Planning Application Ref: **BN/64/19/DOC**

Location: **Former Eastergate Fruit Farm Land at former Eastergate Fruit Farm, Eastergate PO20 3RP**

Description of works: Approval of details reserved by condition imposed under ref **EG/71/14/OUT** relating to Condition Nos **6 - protection of retained trees**, 9 - car parking spaces, 10 - road(s), footways & casual parking areas, 11 - construction management plan, 16 - archaeological investigation, 17 - broadband provision and 22 - refuse & recycling bins

TPP.EFF.22.07.19.472.V1

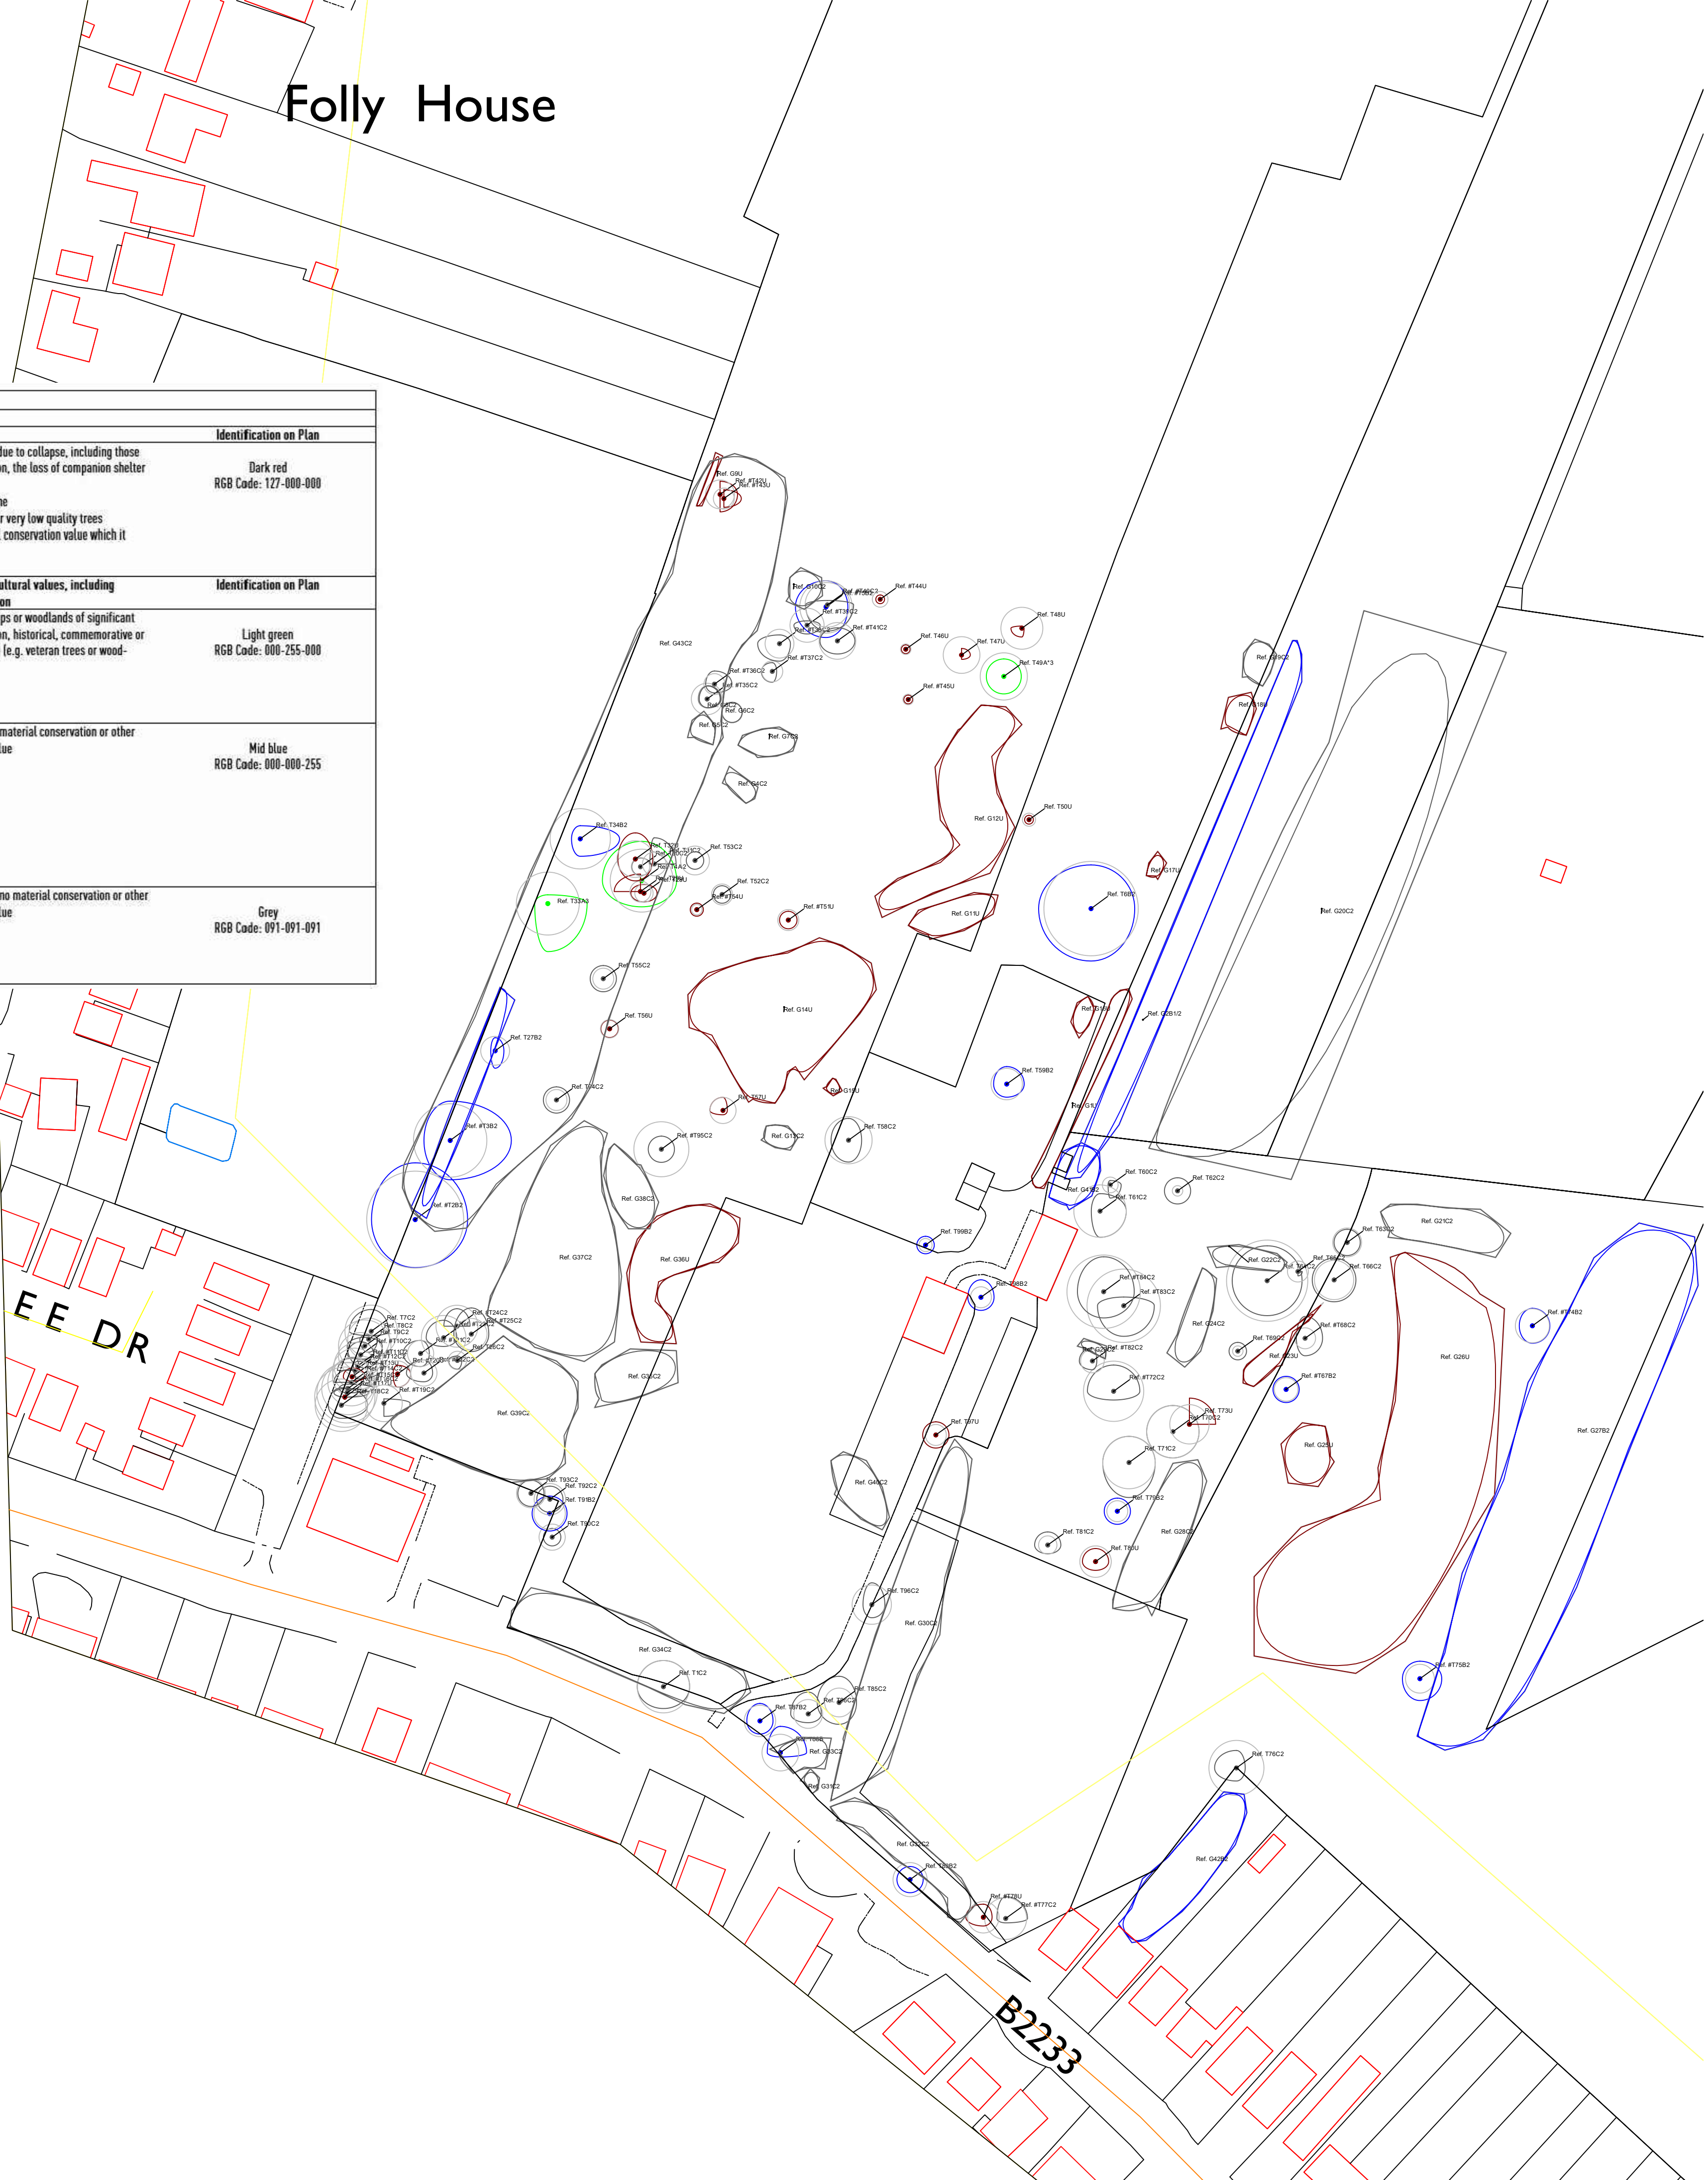
- I have visited the site with a view to discharging the above condition. I had the following approved Tree Protection Plan to refer to:
 - Drawing No. TPP.EFF.22.07.19.472.V1, dated 22.07.2019, from Kingfisher Ecology Ltd.
- The plan and associated Arboricultural Impact Assessment specify 'fit for purpose' fencing to effectively form construction exclusion zones around significant retained trees, as is standard practice and required by BS5837:2012.
- The Tree Protection Plan corresponds with the site layout approved under ref: EG/6/18/RES.

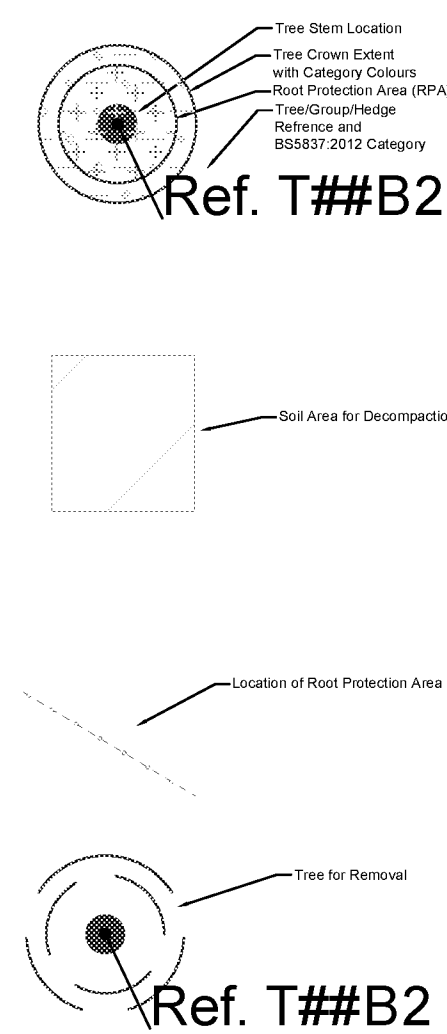
- None of the aforementioned fencing has been installed or even brought to site at this time, although the protection scheme submitted is in principle suitable and should be approved.

- I recommend 'signing off' on Condition 6.
